APPLICATION NO. 03DRB - 01030	PROJECT NO. 1002768
PROJECT NAME Snow Heights Addn (Replat)	
EPC APPLICATION NO.	
APPLICANT / AGENT SSW Sarah	PHONE NO. 998-0303
ZONE ATLAS PAGE H-20

IR ONE STOP COMMENT FORM LOG

REF: LOT 3, BLOCK A, SNOW HEIGHTS ADDITION

PLAT OF
 LOT 3, BLOCK "A"
 SNOW HEIGHTS ADDITION
 SEC. 8, T. 10 N., R. 4 E., N.M.P.M.
 CITY OF ALBUQUERQUE
 BERNALILLO COUNTY, NEW MEXICO
 JUNE 2003

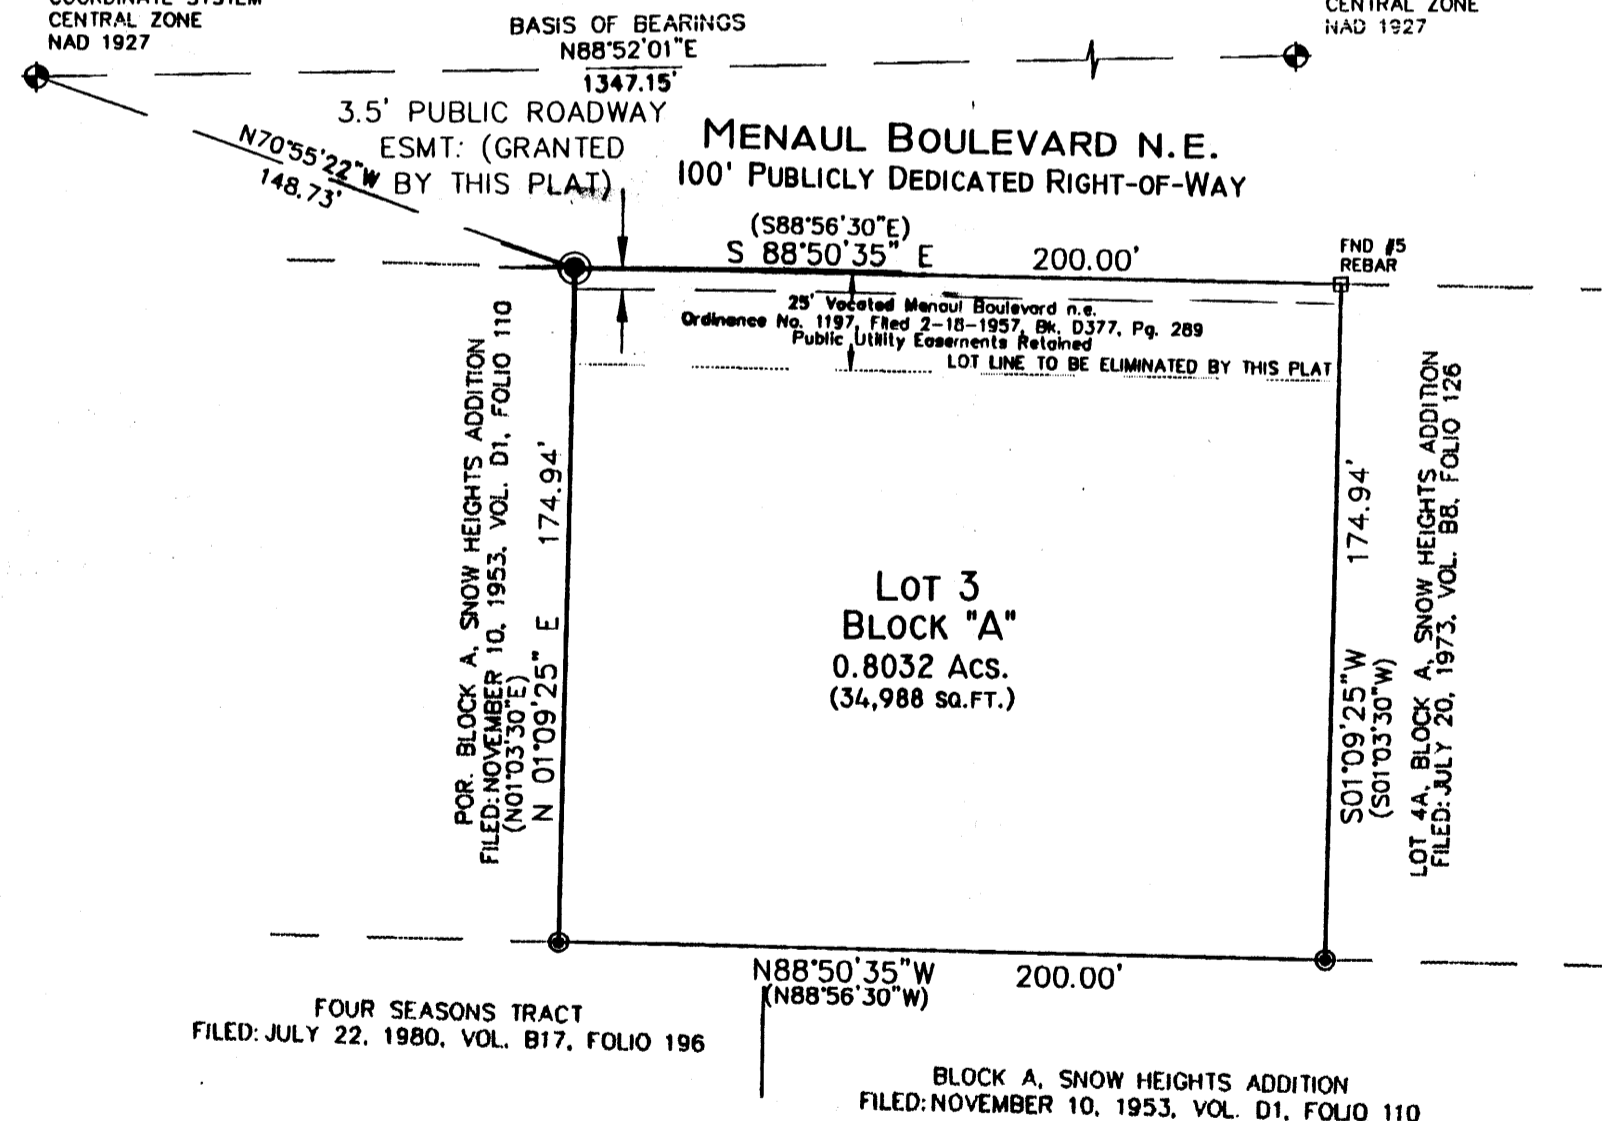
TRANSPORTATION DEV (505) 924-3990		
PLANS DISAPPROVED	DATE 6-19-03	DATE
PLANS APPROVED	DATE 6-24-03 JRM	DATE
COMMENTS:		
- Public Roadway EBMT - UP TO 10' from face of curb.
